Engineers Comments Regarding Surface Water Drainage

Application Reference:	CM/18/25/DOC	Reviewer Reference:	ADC/EXT12/GK
Planning Officer:	Jessica Riches	Date of Review:	06/08/2025
Site Name:	Land West of Church Lane & South of Horsemere Green Lane Climping		
Application Description:	Approval of details reserved by condition imposed under reference CM/1/17/OUT relating to condition number 9 - i. surface water drainage scheme and ii. a foul water drainage scheme and condition number 10 - i./ ii. watercourses and iii. rising main and foul sewer pipe.		
Assessment Number:	1 of 2

NoApplication Reference: CM/18/25/DOC Site Name: Land to the West of Church Lane and South of Horsemere Green Lane Climping	Initial Issue Date: Issue Date: 02/0102024 Reviewer Reference: ADC/EXT12/GK
--	--

(Maximum pipe size 450mm diameter)

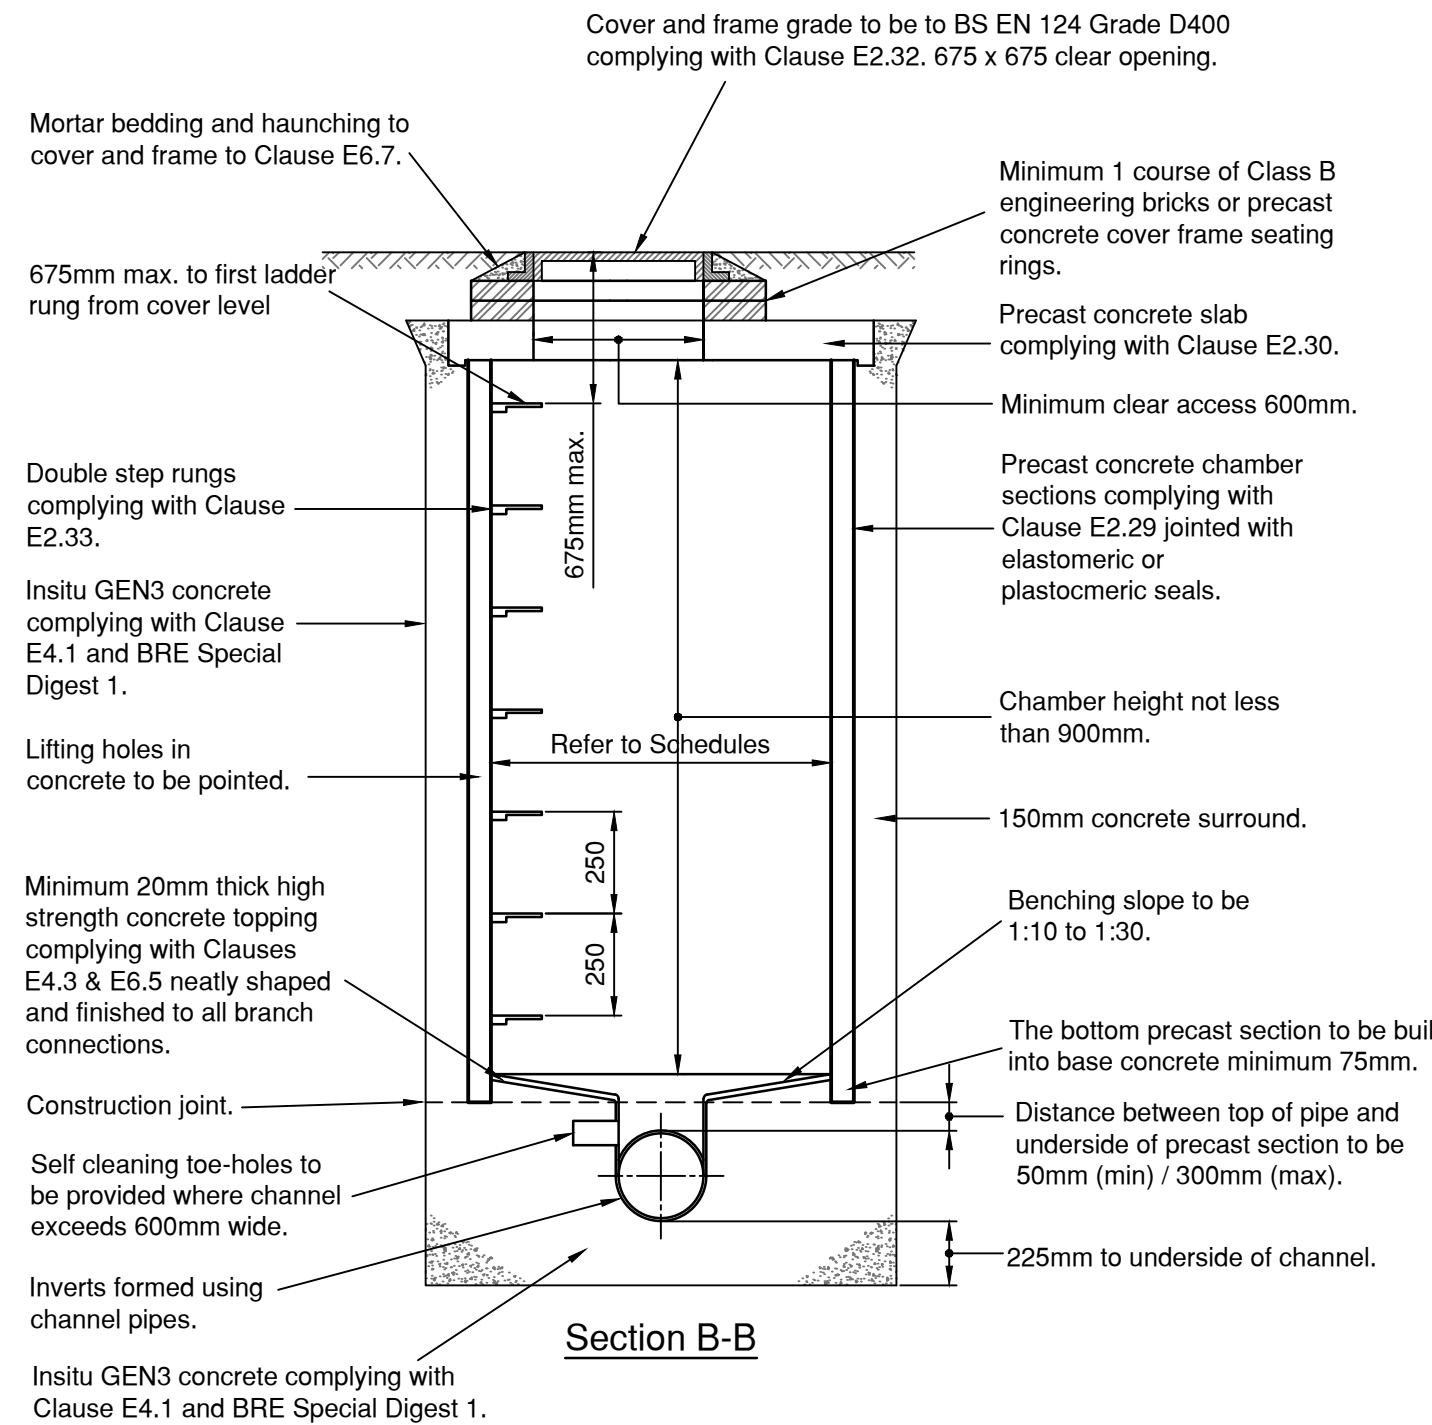
9.	No manhole schedules have been provided.	No comments – refer to updated design.	Manhole schedule submitted but many manholes are missing probably due to wrong printing options. All the manholes are shown as Type E which is impossible. Please also note which manholes are catchpits. All the manholes have a diameter of 450 which is wrong in many cases. Please amend. Please specify the cover type on manhole schedule. Clarify how the shallow pipes will be protected.	A 10% urban creep allowance has been applied to all plots. Please refer to the impermeable areas plans included with the response pack - FOR-E5139-489 to 491.	All the manholes prior to attenuation tanks and the watercourses should be catchpits. Please also specify the cover type of each manhole.

Drawing file: CM_18_25_DOC / D2385 D495 - Swale Section.pdf

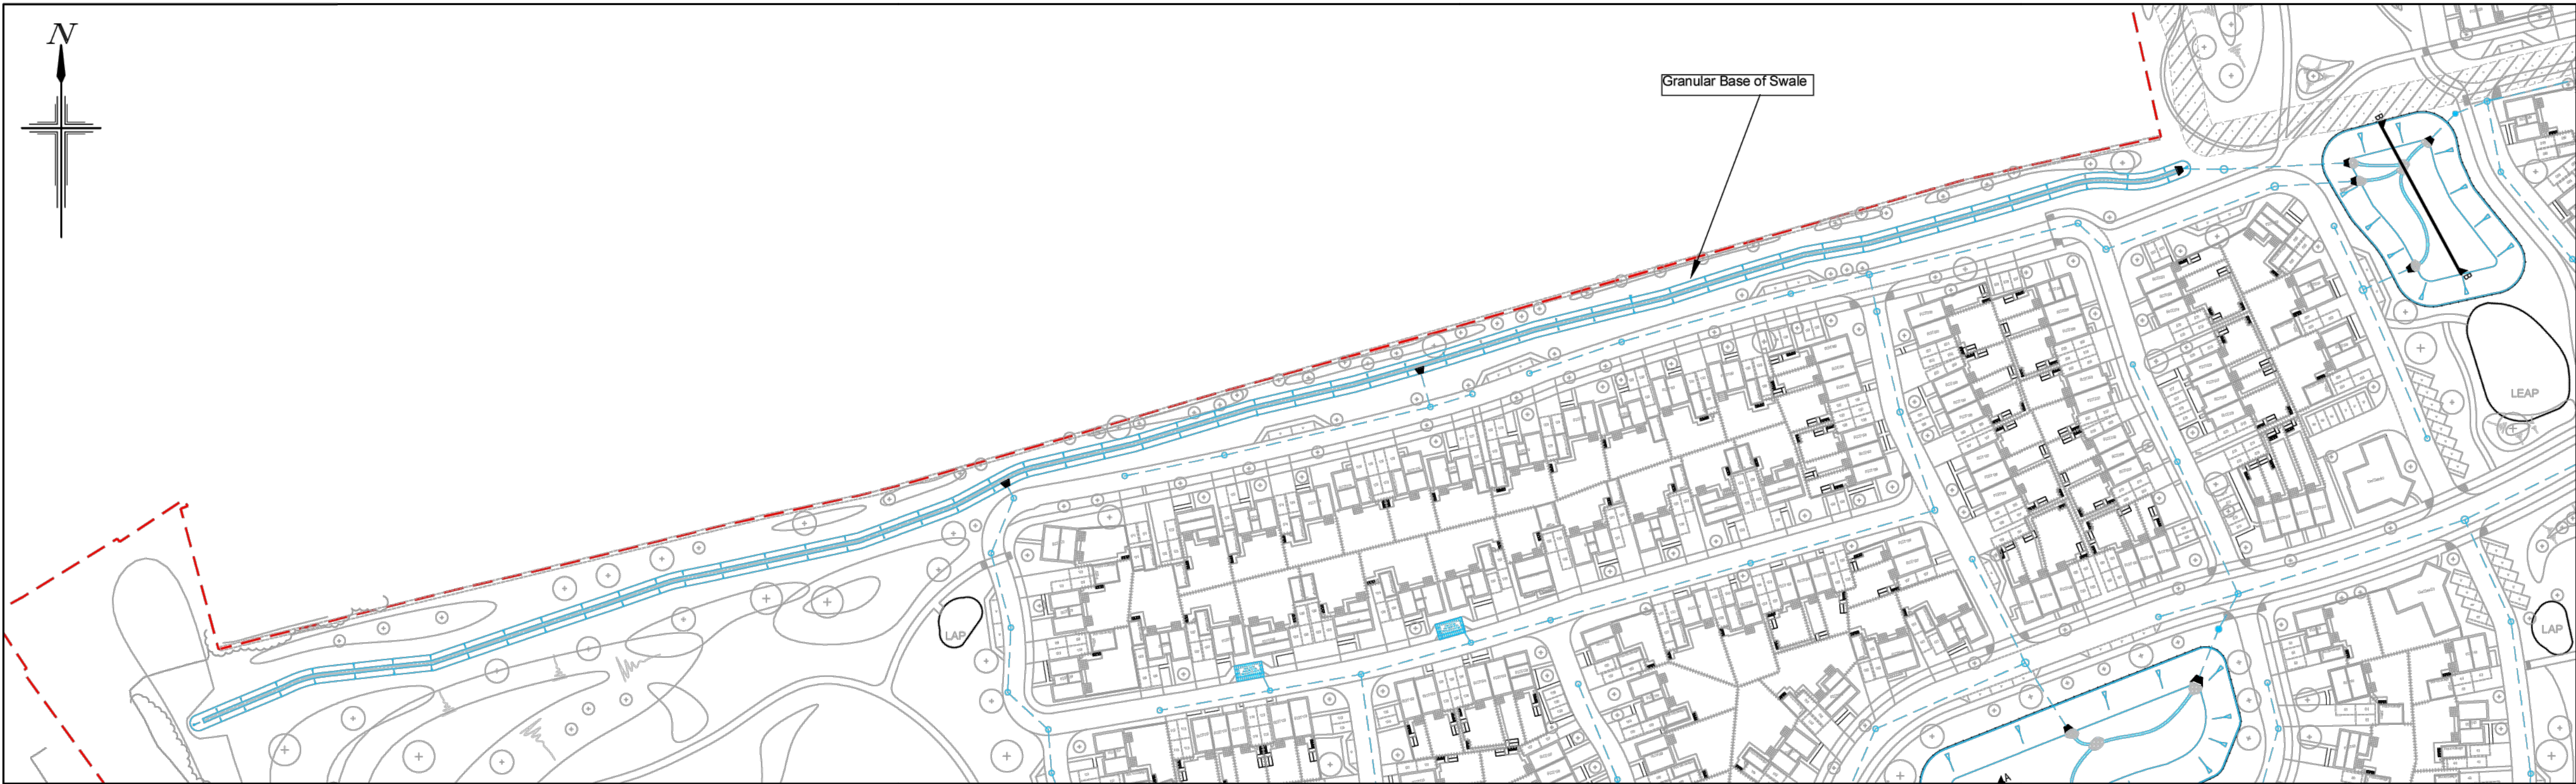
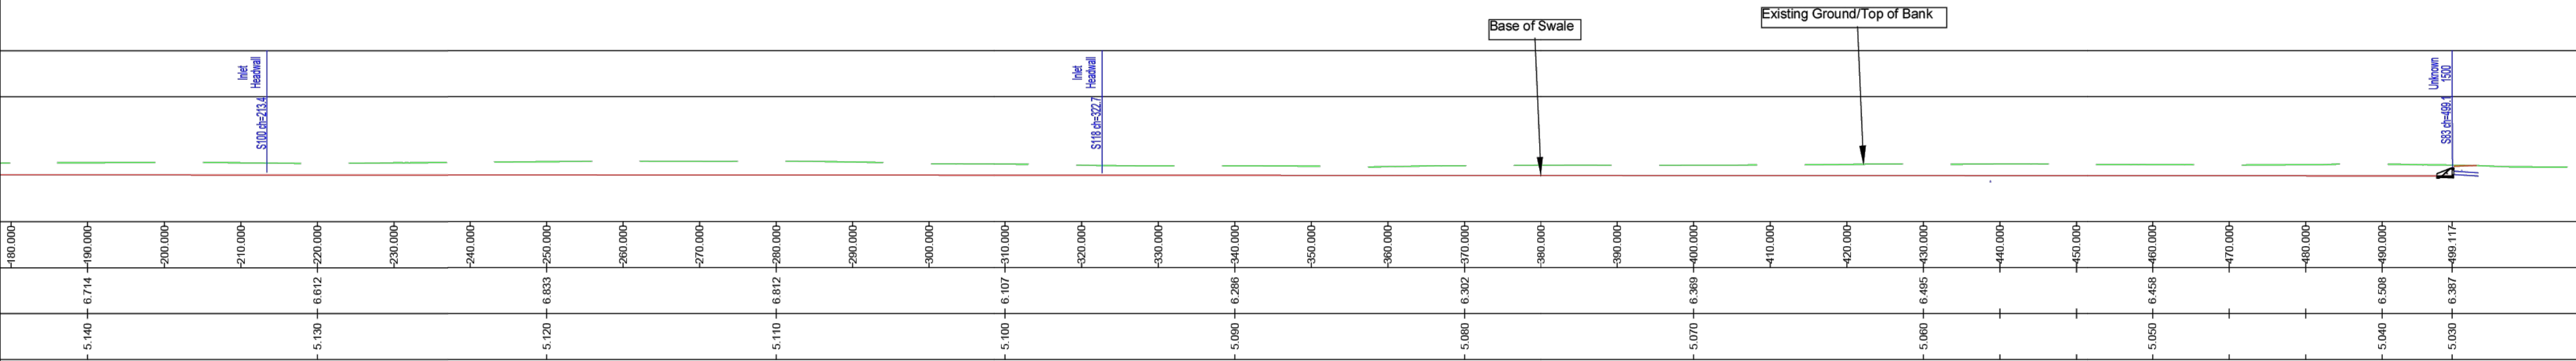
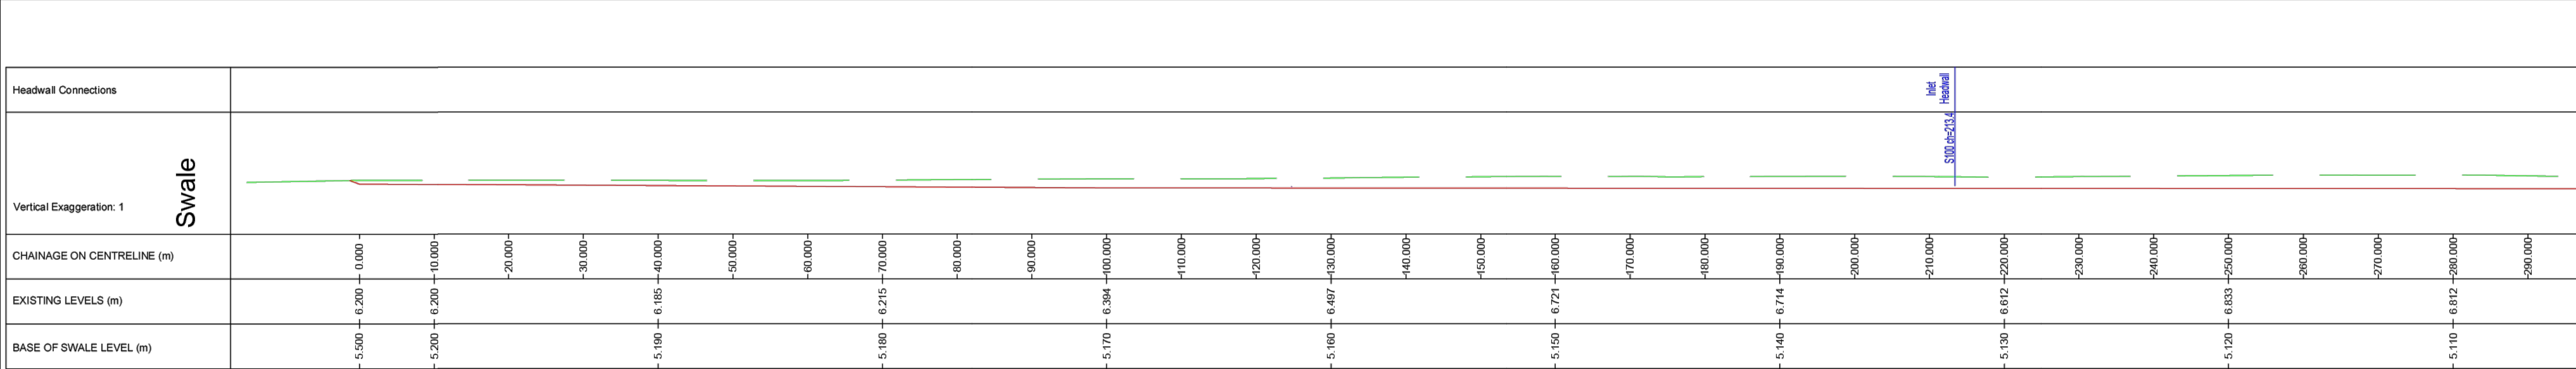
13.	A new water course is proposed along the northern site boundary. Is this just a conveyance swale for the onsite system or does this receive flows from anywhere offsite? There is no mention of this in the FRA. It is noted that the side slopes are 1:2 these should be reduced to 1:3 as it is noted that the 'swale' is up to 1.9m deep in some places.	No comments – refer to updated design.	Comment remains.	This is a proposed swale for conveying flows from the proposed site. SI works done by G and W encountered groundwater at 1.5m bgl in the road south of the swale. The swale is proposed as a conveyancing feature and will not infiltrate into the ground. Swale banks shall be 1:3 with a granular sub-base. For the swale levels refer to FOR-E5139-492.	Comment closed.

Drawing file: CM_18_25_DOC / FOR-E5139-454 D  Domestic Drainage Sheet 4 of 22.pdf

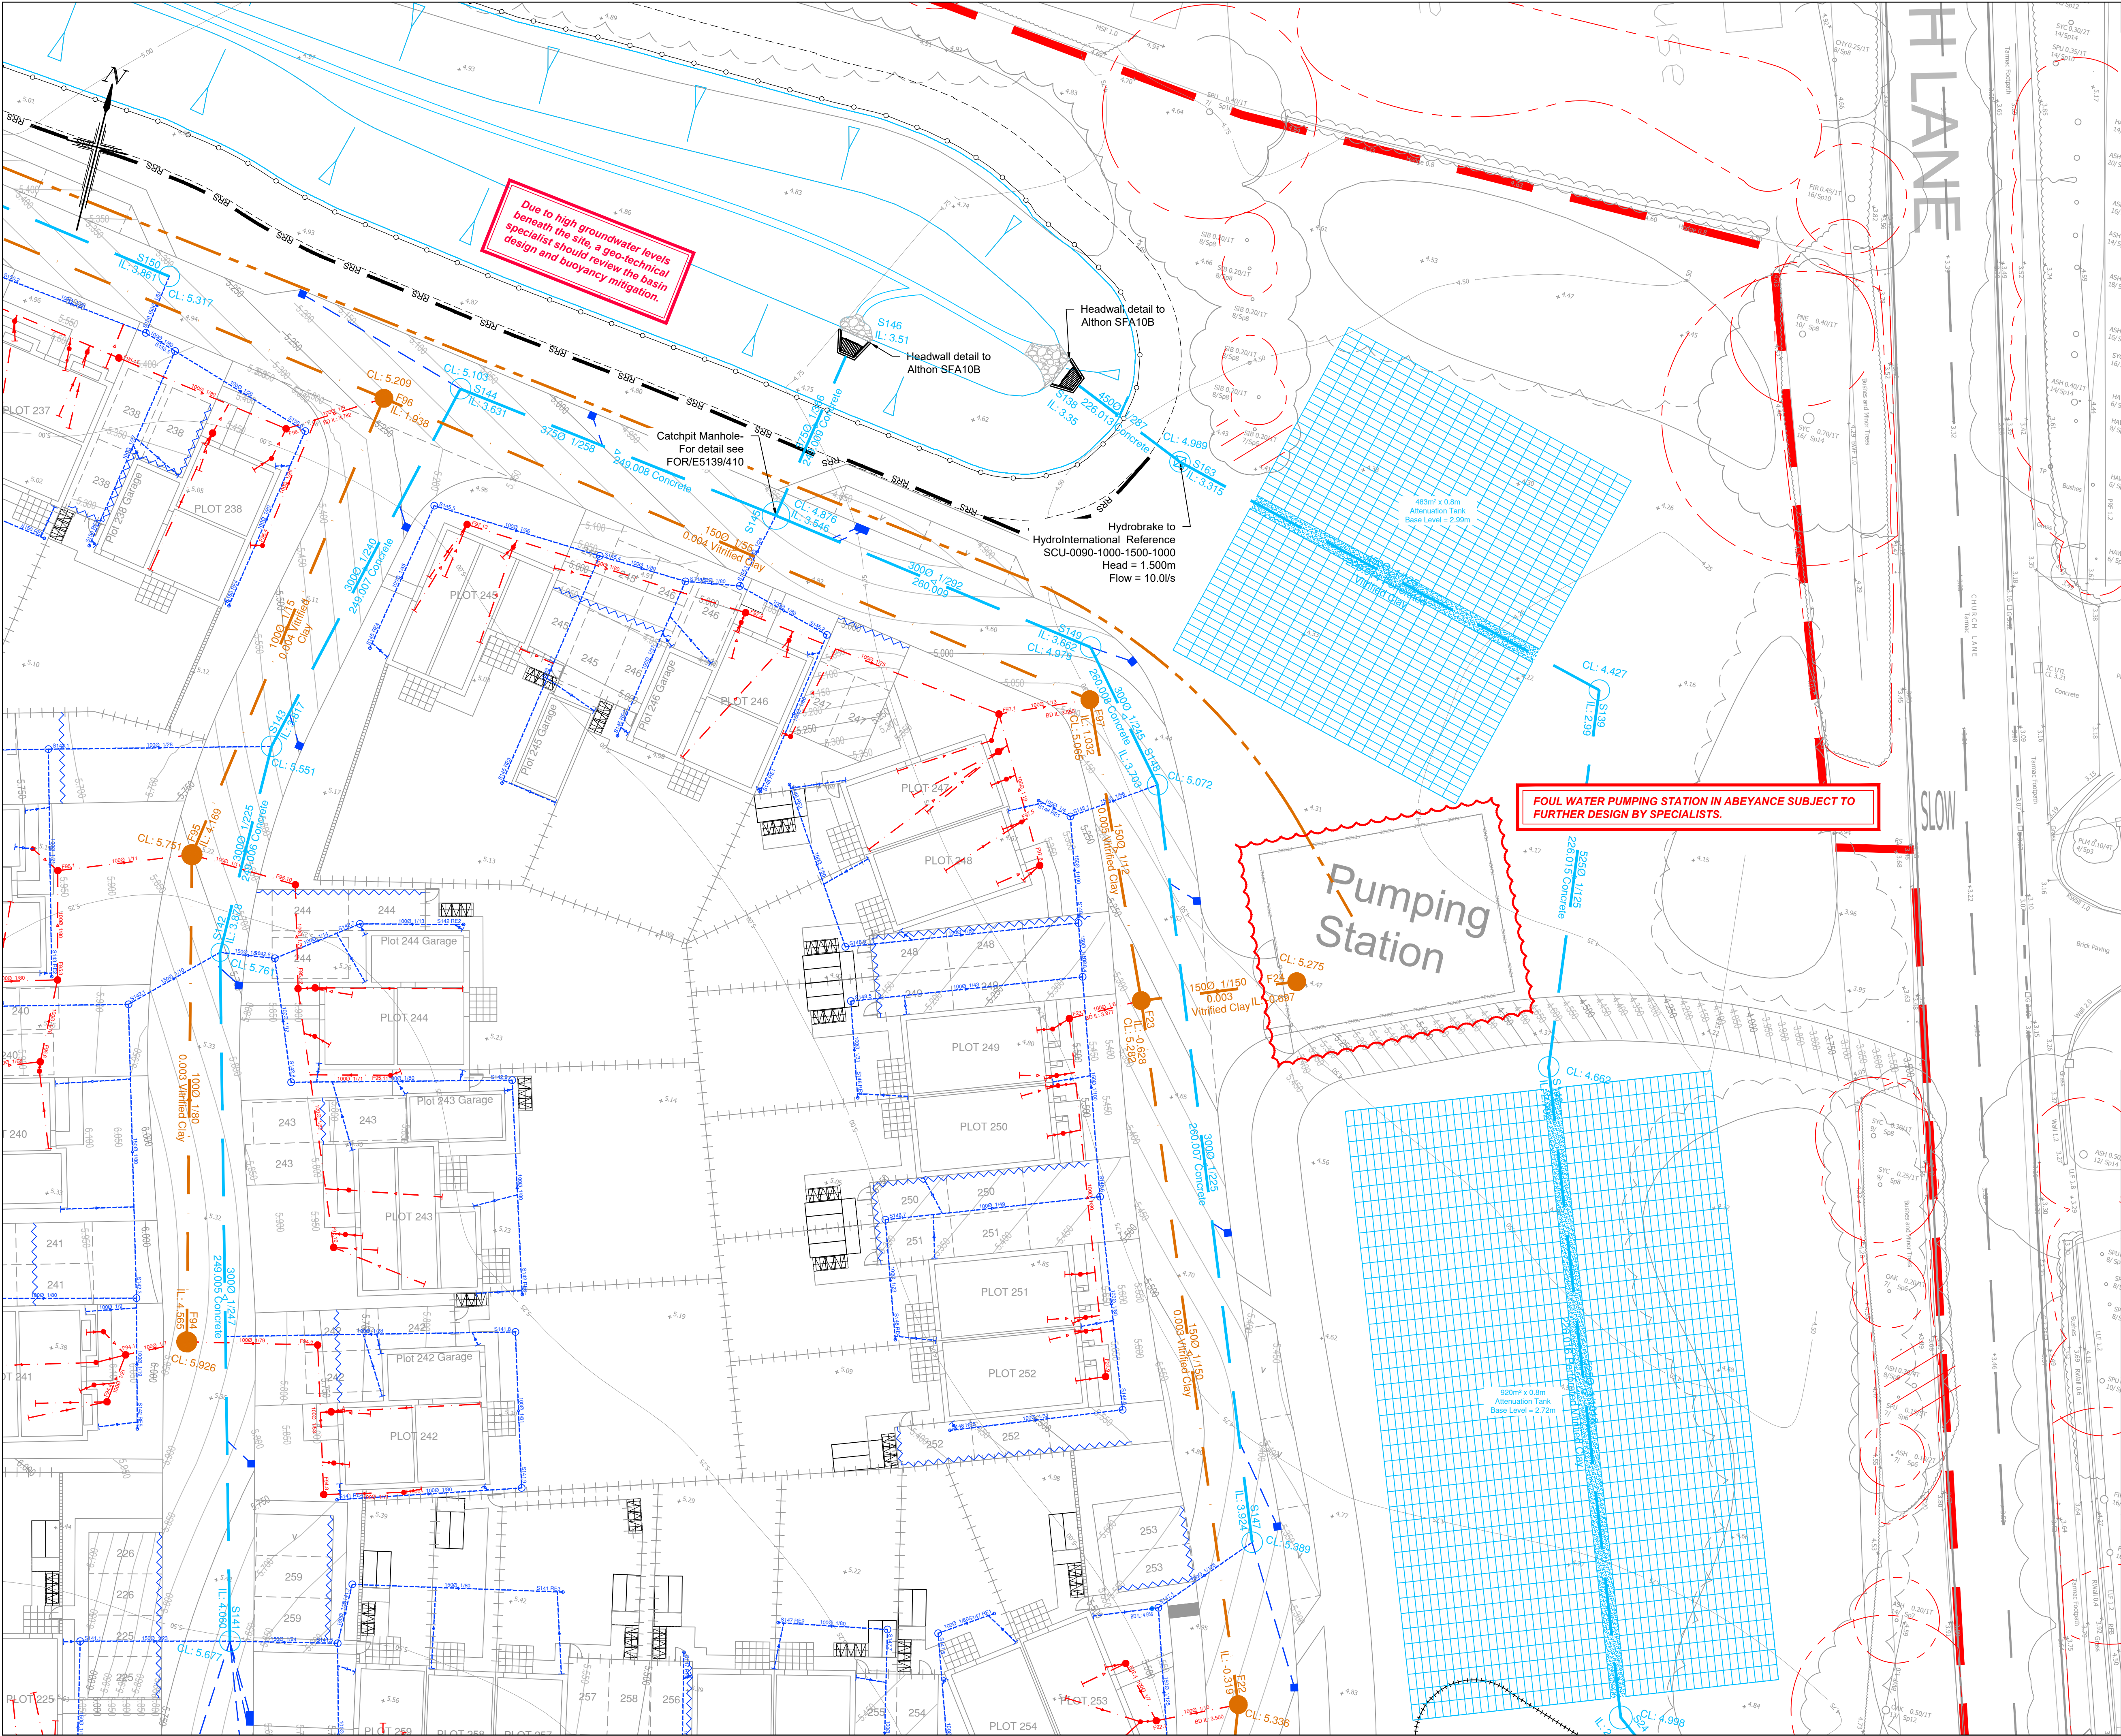
27.			Make clear the text shown at the attenuation tanks at drawing FOR/E5139/454.	Plans updated as per comment	Comment closed.
